**From:**  
**To:** [Mathias Franklin](#)  
**Cc:** [DCAdmin](#)  
**Subject:** Prickleden Mill- Planning Submission ref: 2023/91491 - Letter of Objection  
**Date:** 12 July 2023 20:31:19  
**Attachments:** [Prickleden Objection letter110723.docx](#)  
[Prickleden Mill Accommodation Schedule 2023.xlsx](#)

We are writing to object to the planning application lodged at **Prickleden Mills ref:2023/91491**

ELISTON HOMES			
PRICKLEDEN MILLS HOLMFIRTH			
Project No	Drawing No	Rev	
2659	(100)11	F	
PROPOSED SITE SECTIONS SHEET 1 OF 2			
Scale	Drawn	Drawn By	Authorised By
1:200@ A0	FEB21	JF	JC
Purpose of Issue			
Planning: ☒ Building Regs: ☐ Tenancy: ☐ Conservation: ☐ Other: ☐

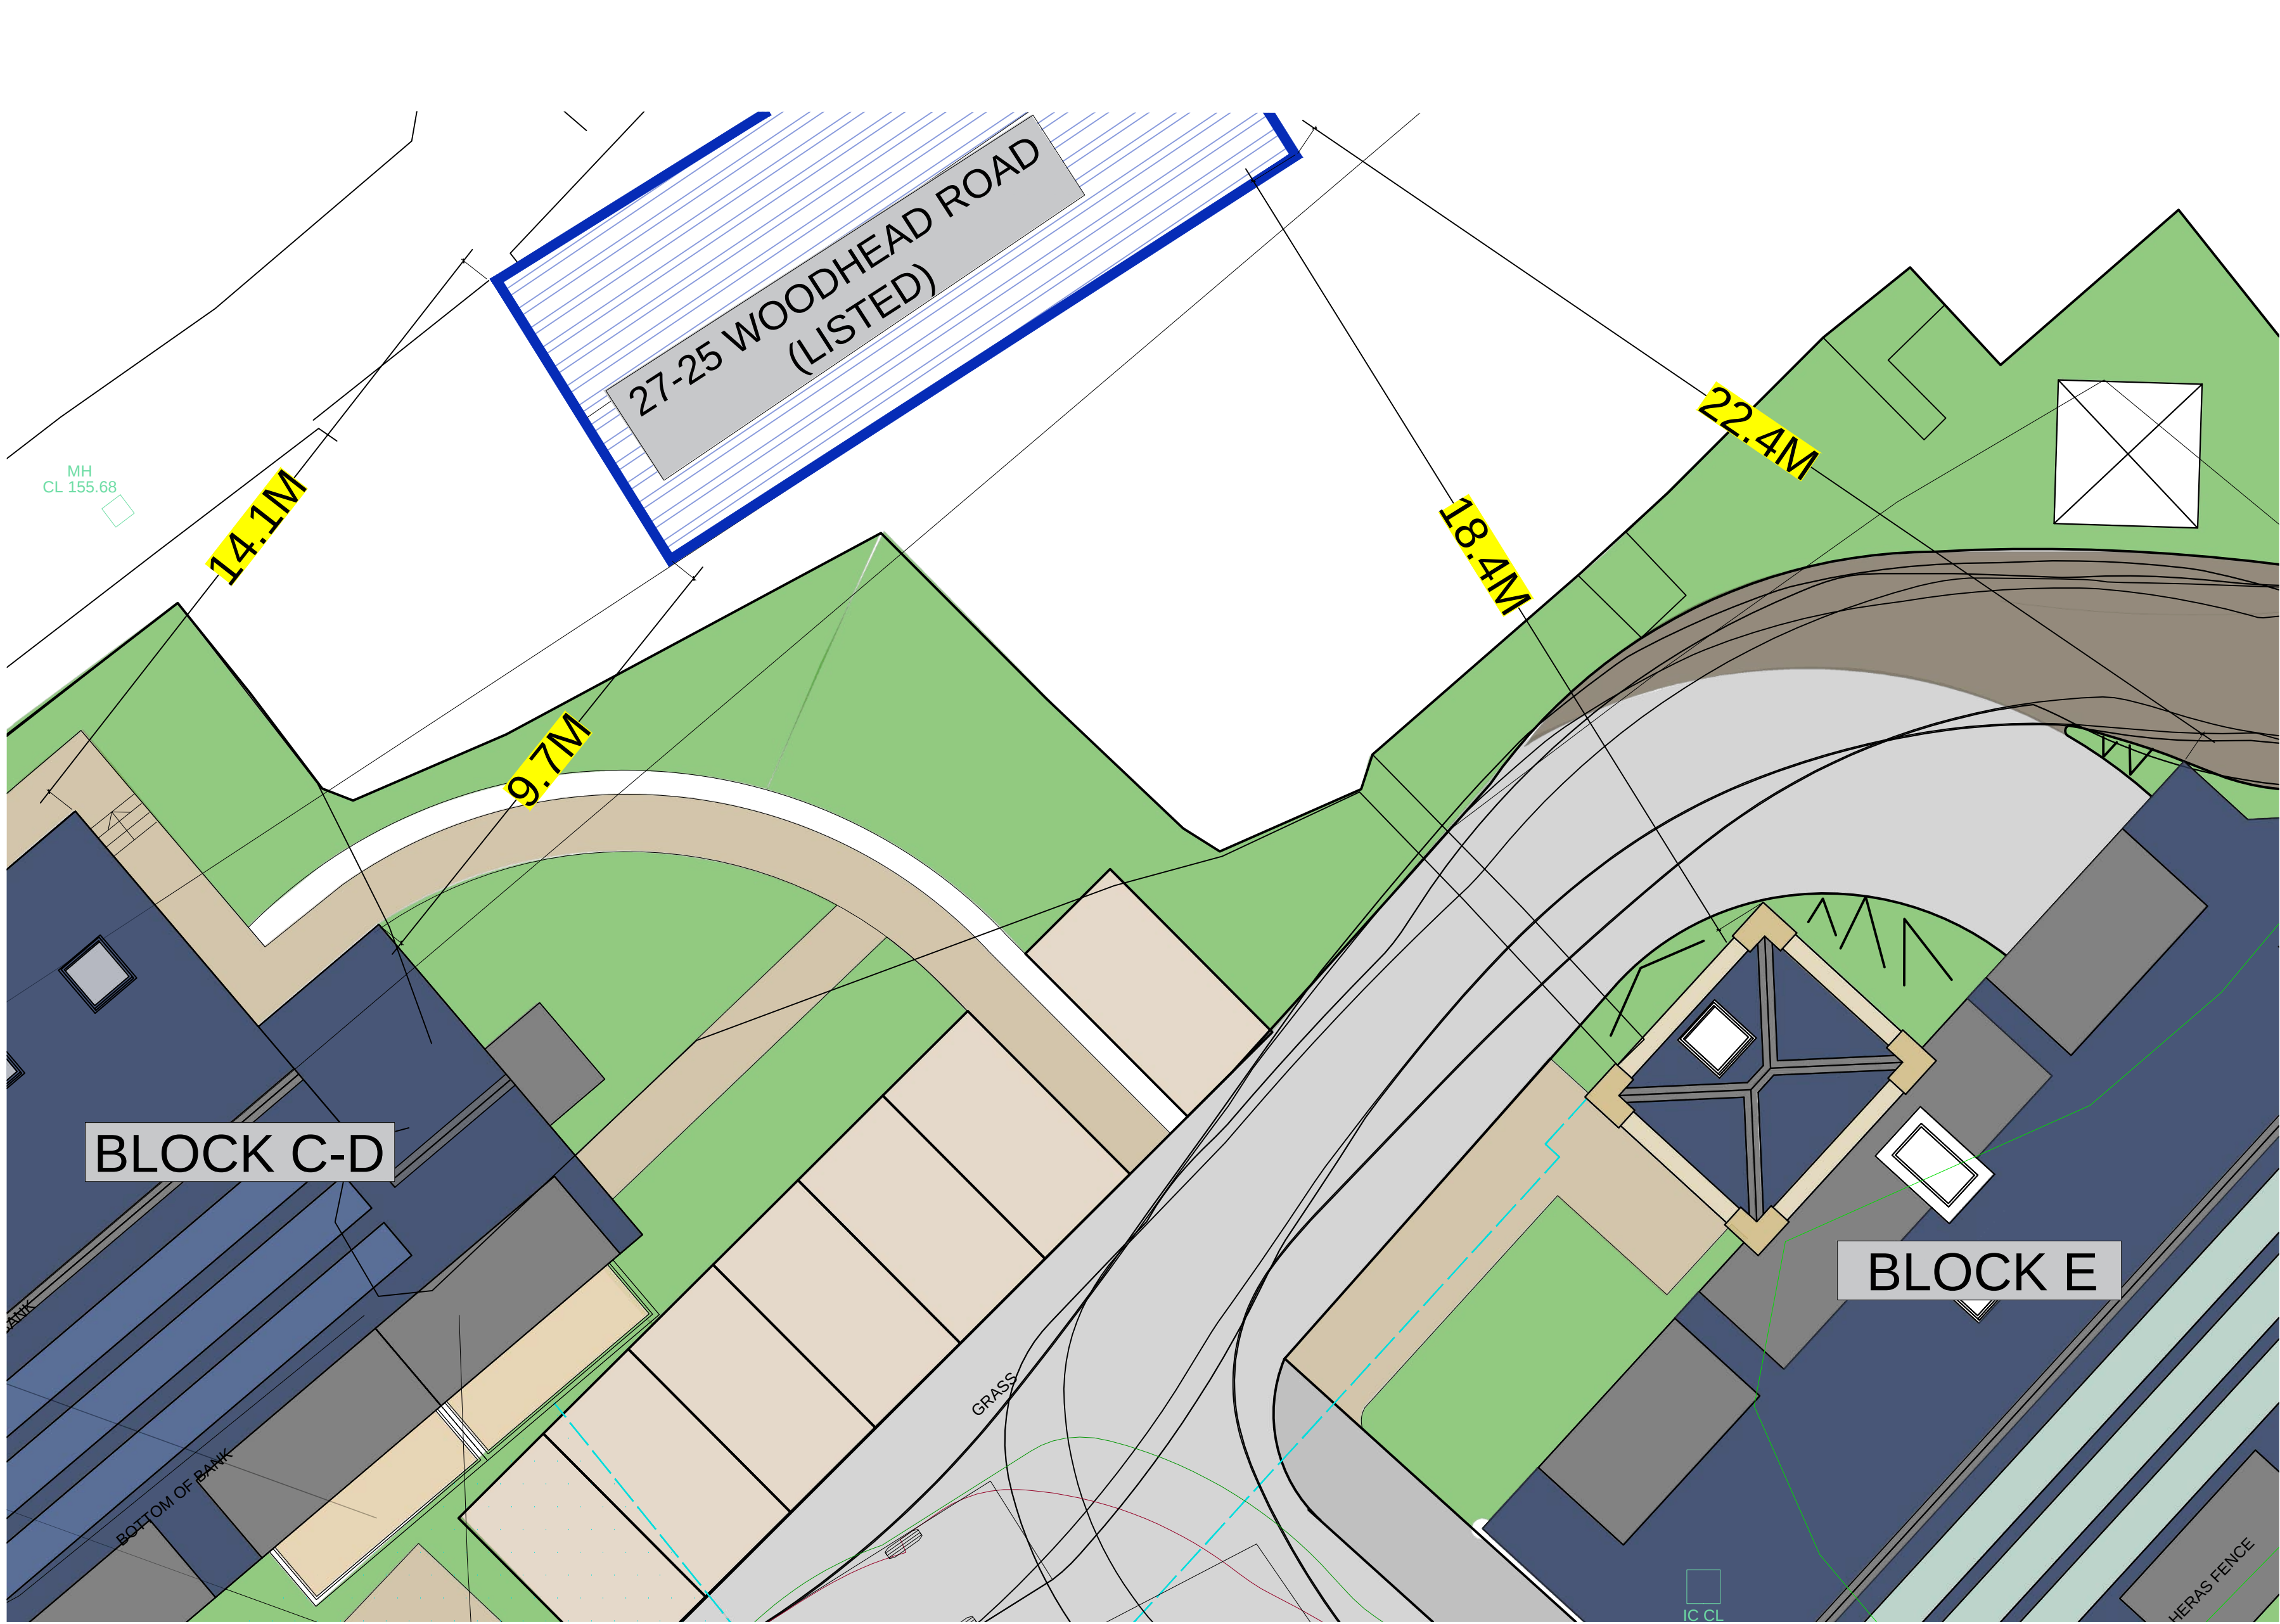
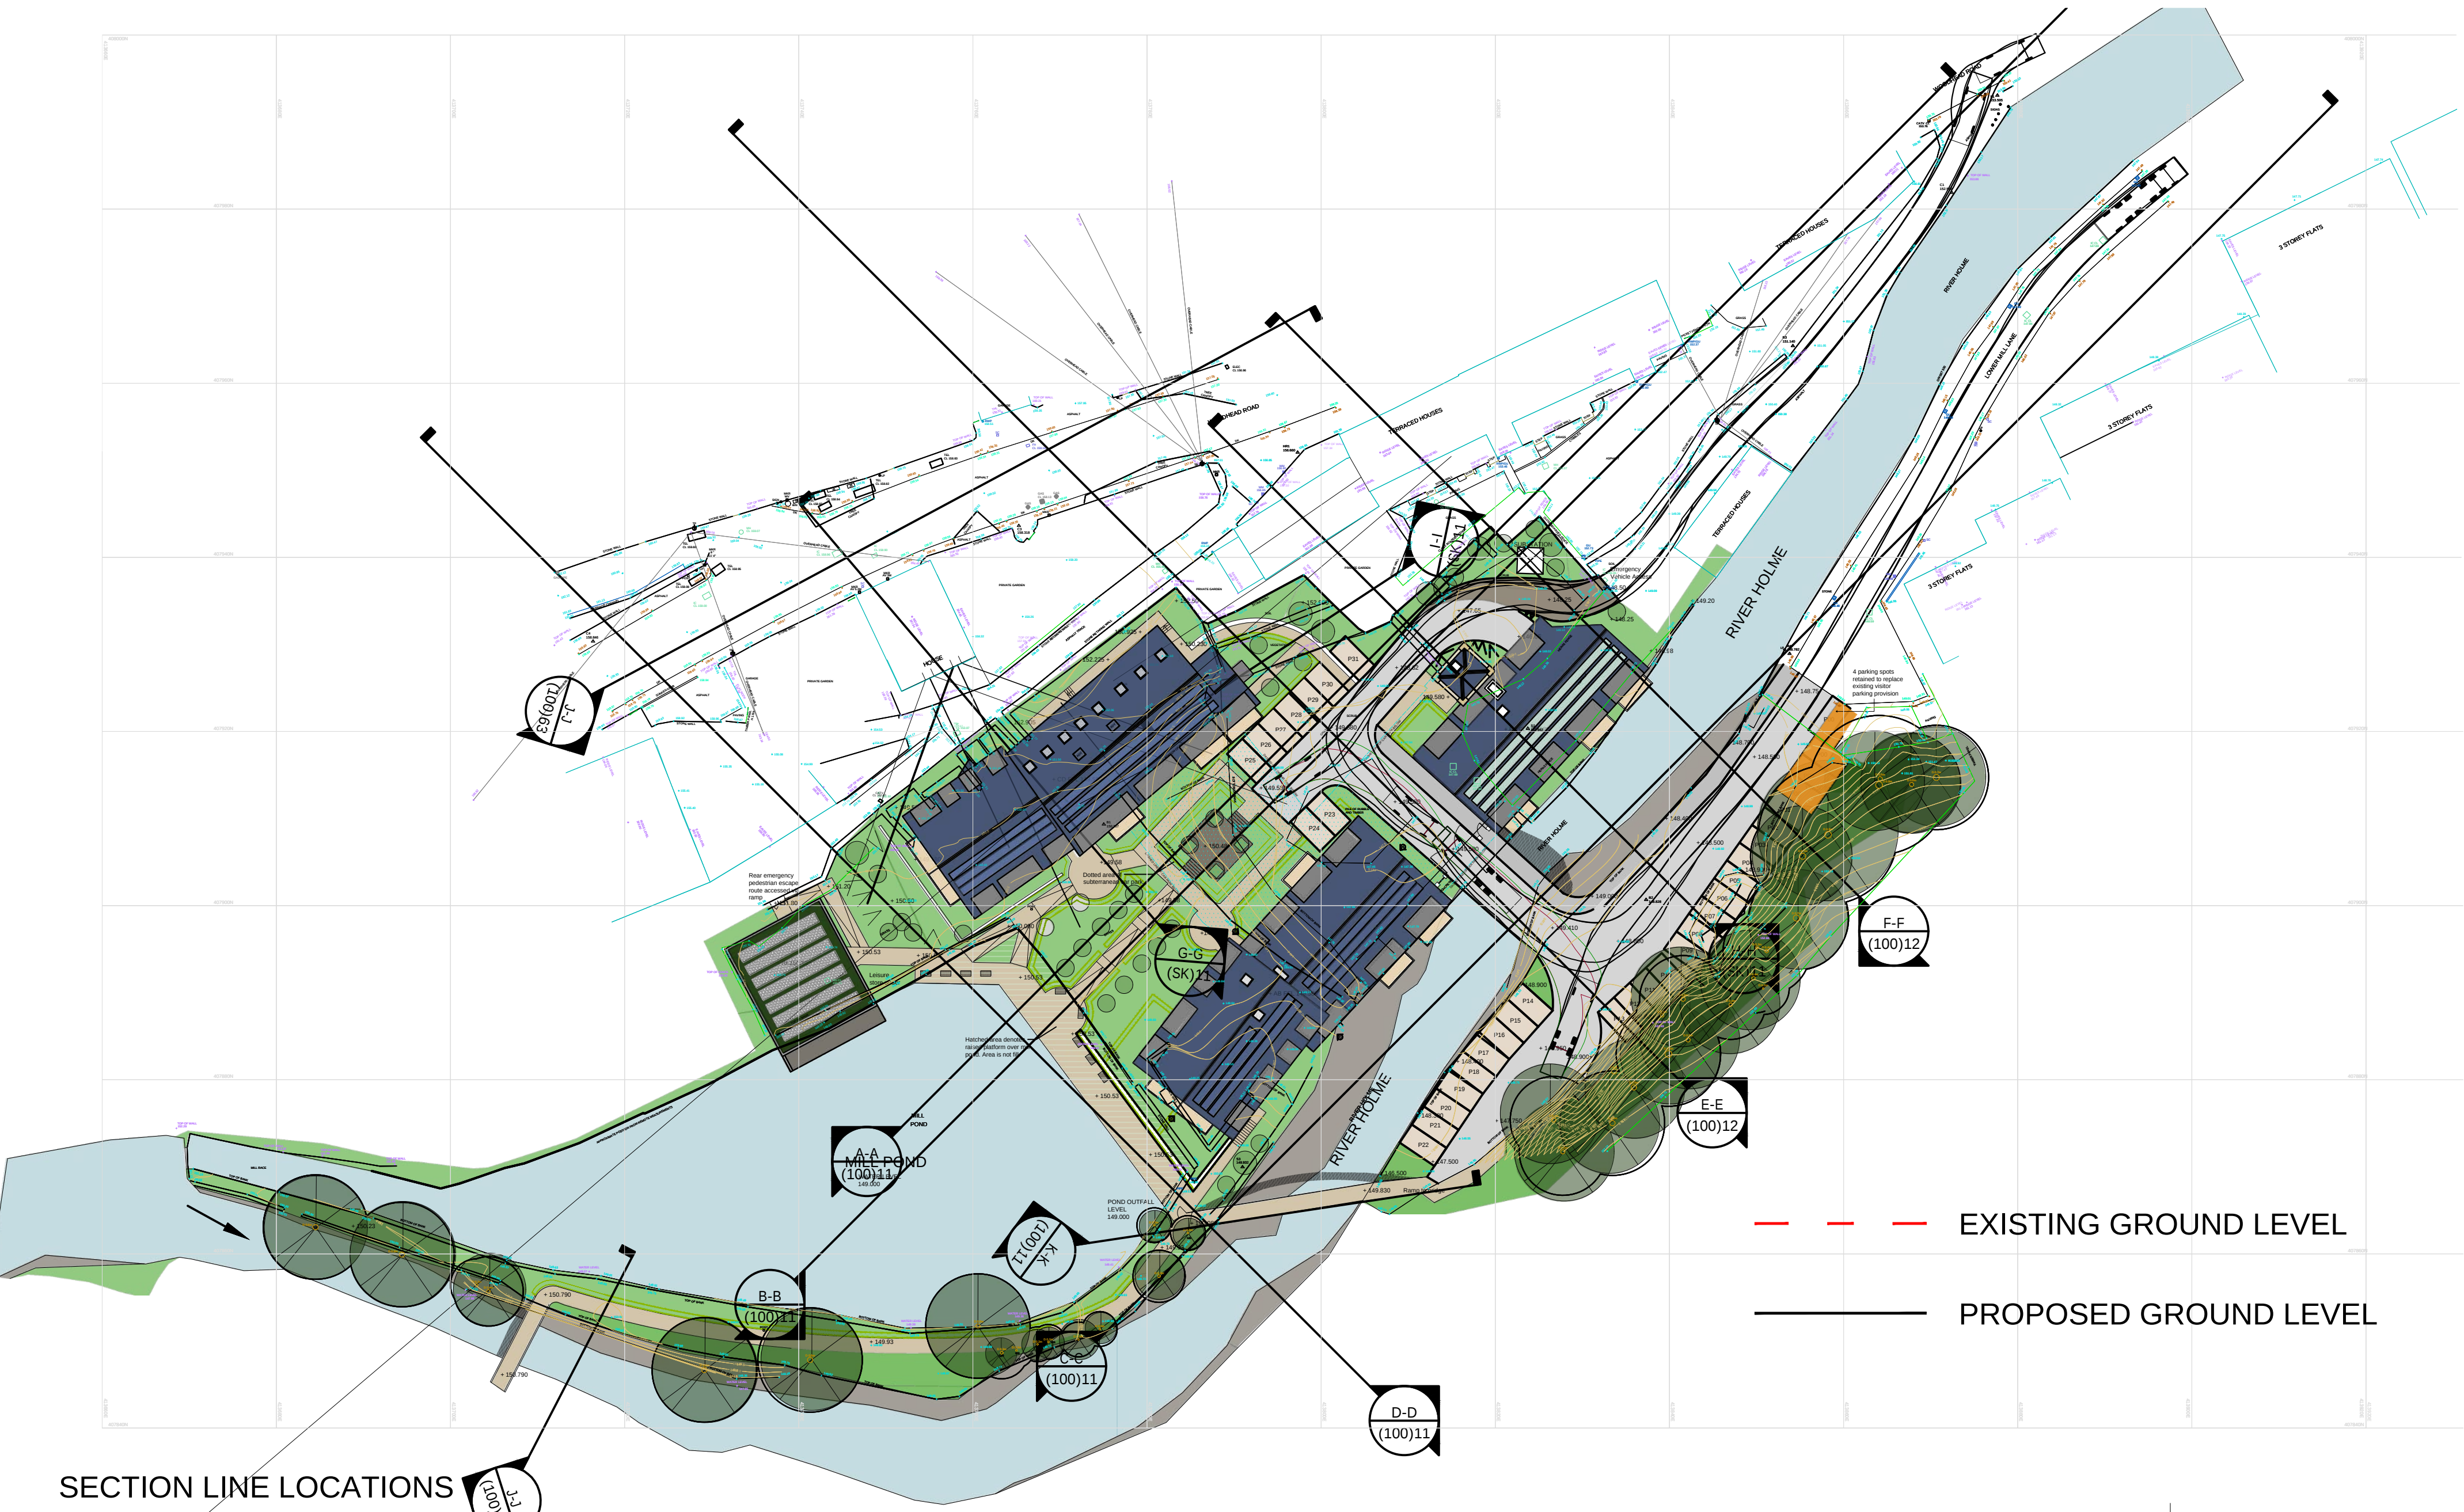
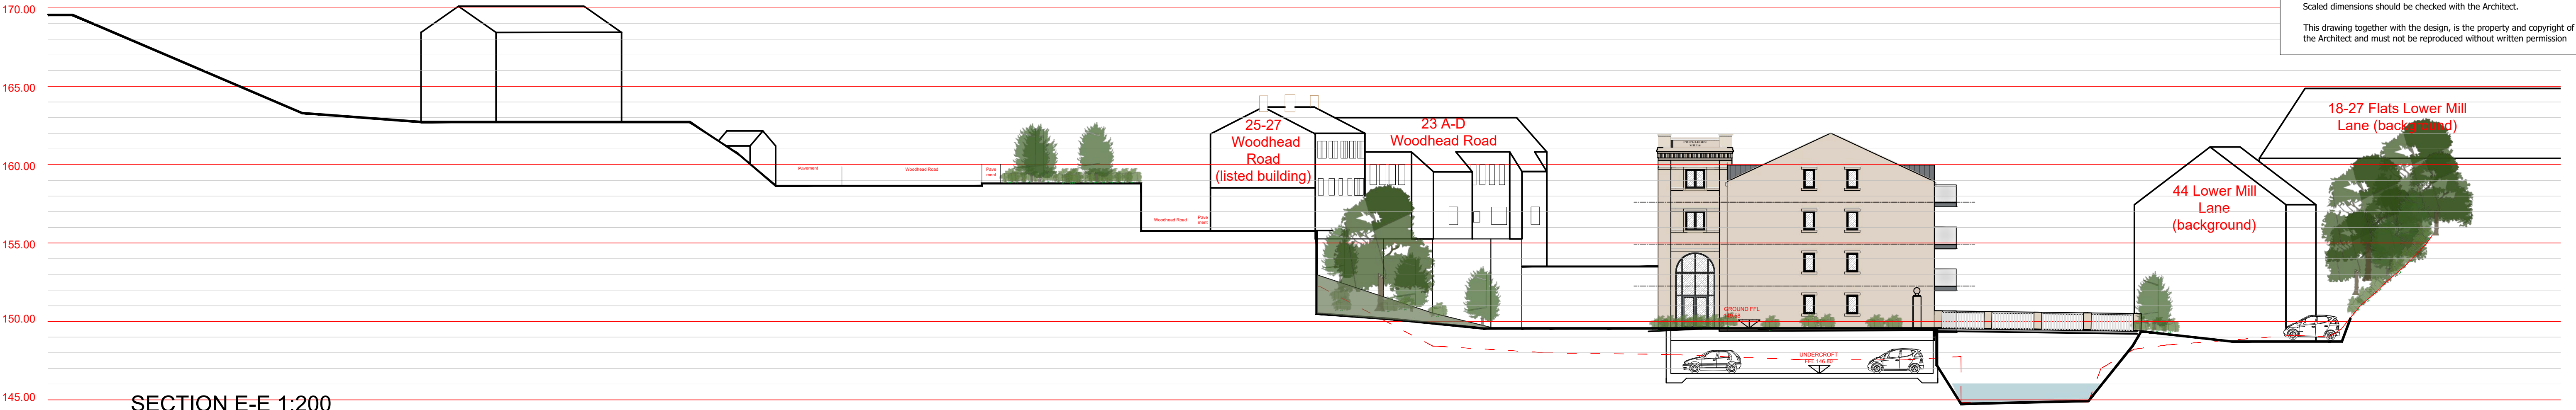
5. The eaves height of the revised proposal in places is up to 170m AOD making it in places 3 storeys higher than the consented scheme. . Some of the buildings proposed will exceed the height of the Listed Buildings at 25-27 Woodhead Road which will be dwarfed and obscured by these revised proposals in further offence to policy LP35.

6. The existing ground level is proposed to be raised by up to 3m to accommodate underground car parking . Aside from exacerbating the problems of height, scale and massing of the proposals, this is in contradiction to policy LP20 for Sustainable Travel with its prioritisation of private vehicles in direct contravention of the policies set out in the hierarchy in the policy itself.

10. The proposal may be in breach of policy LP28 Drainage. The developer should be required to demonstrate outline proposals on how SuDS will be implemented , and should not be permitted to raise the Ground levels and especially not by the enormous amounts shown in the plans.
